Date: 03-Nov-2023
Our Ref: 2023/92180

**Discharge of condition 15 (Validation Report) of previous permission 2016/91026 for
erection of 168 student studios with communal areas
Land Off, Manchester Road, Huddersfield, HD1 3JA
Application Number: 2023/92180**

- A Remediation Validation Report authored by Evolve Geo-Environmental Limited, dated 11th October 2023 (ref: EGE-23-09-18-01)

Figure No. and Title	Figure II - Approximate Topsoil Sampling Plan
Project Name	Block A to C, Huddersfield Waterfront, Manchester Road, Huddersfield
Client	Hexa Consulting Limited
Service	Topsoil Validation Sampling
Date of Issue	October 2023
Project number	EGE-23-09-18-01

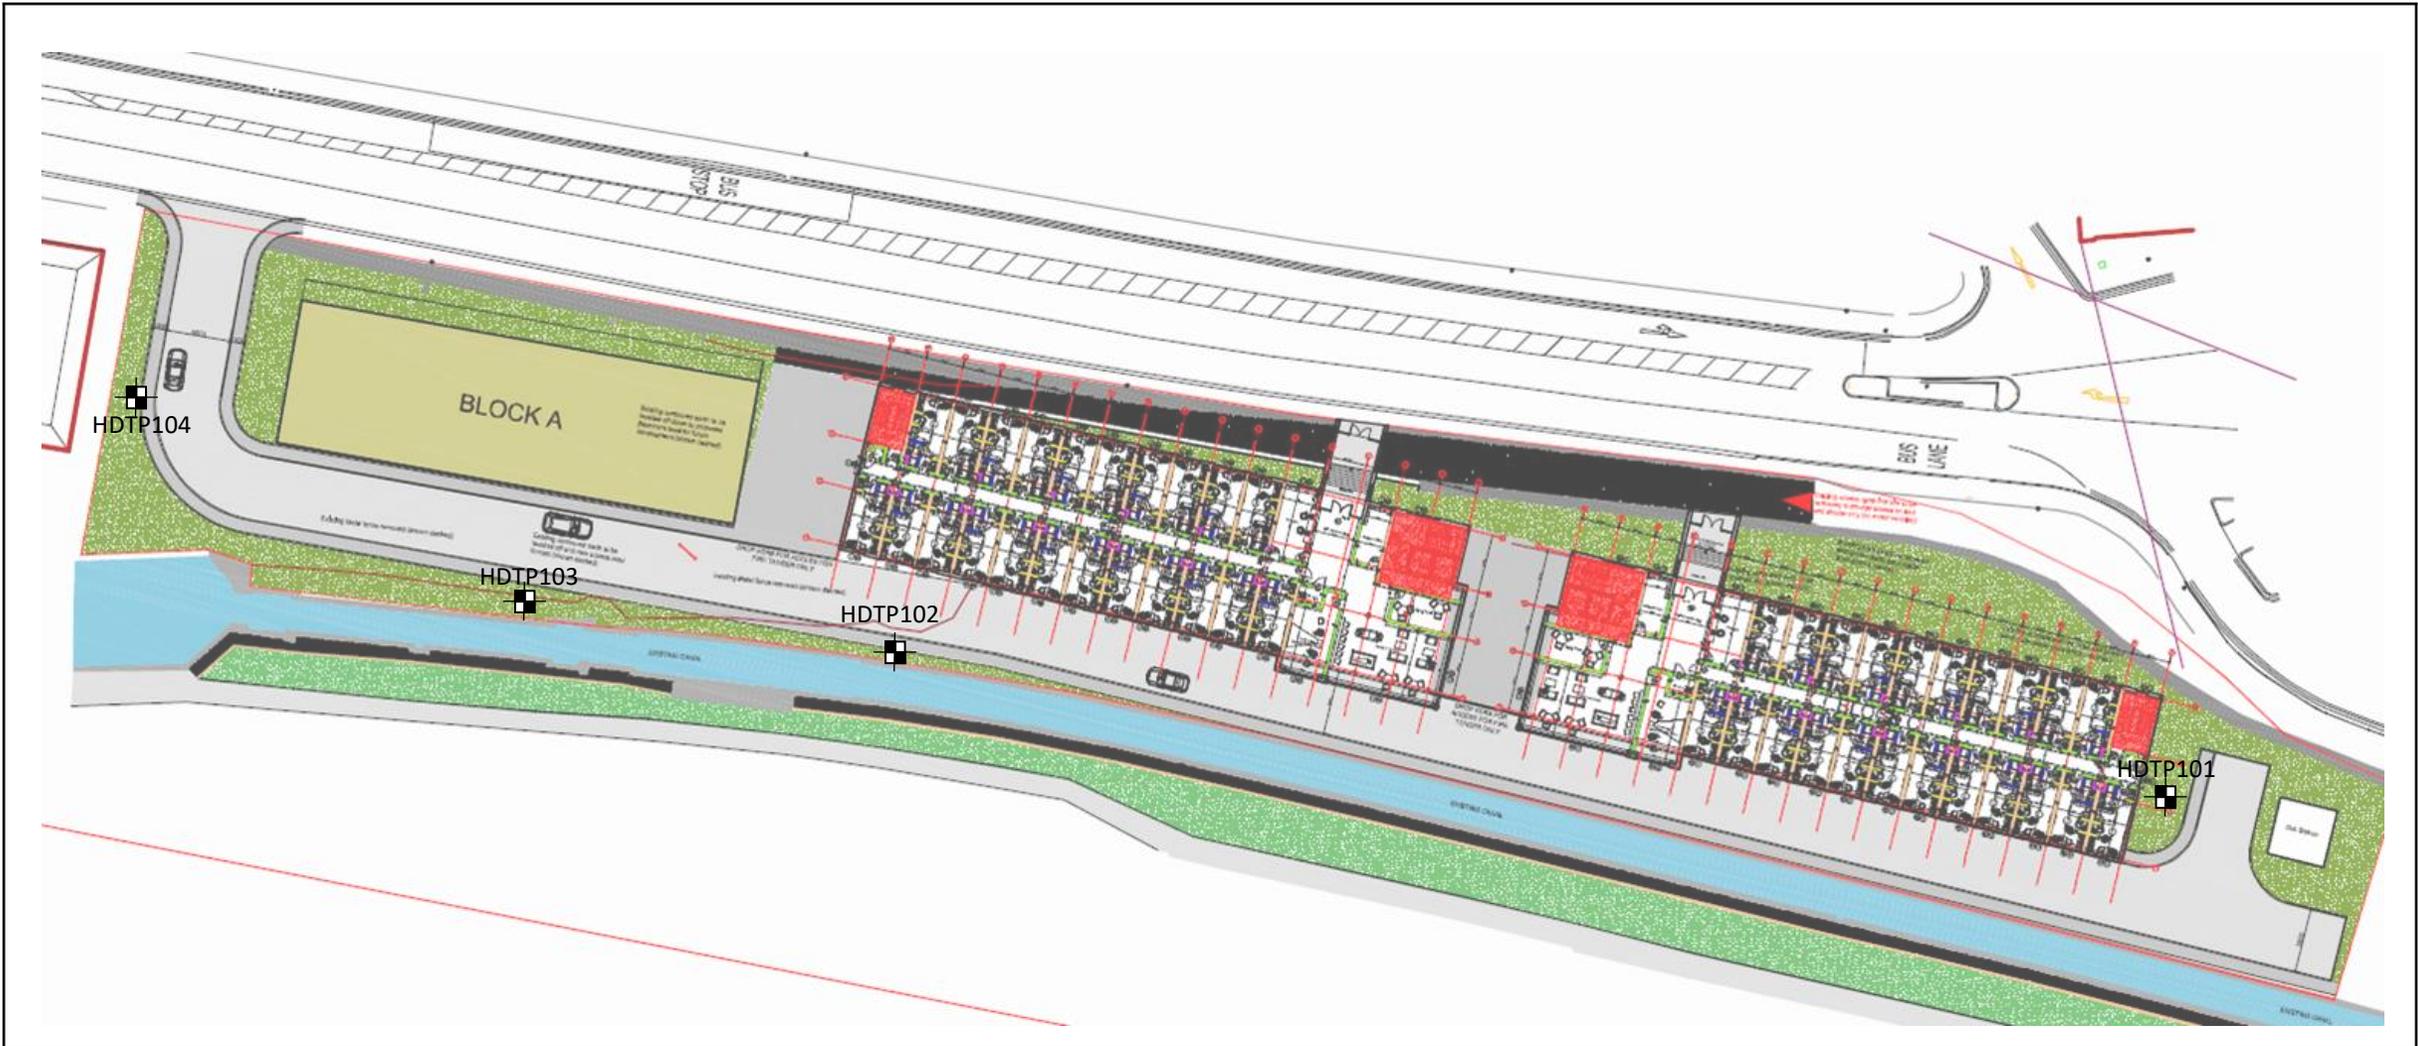
- Only 1 trial pit has been done in for Area A. It is unclear how this can demonstrate the absence of contamination, to a high degree a confidence.
- Appendix 2 is supposed to contain the delivery notes of imported material, but this has not been provided. Moreover, no samples have been provided to confirm the suitability of any imported material. This does not appear to be in accordance with best practice guidance.
- The material identified in all four trial pits is generally gravelly sandy clay soils (made ground) which appears to be the same as the generally ground conditions proven in the Phase 2 investigation.
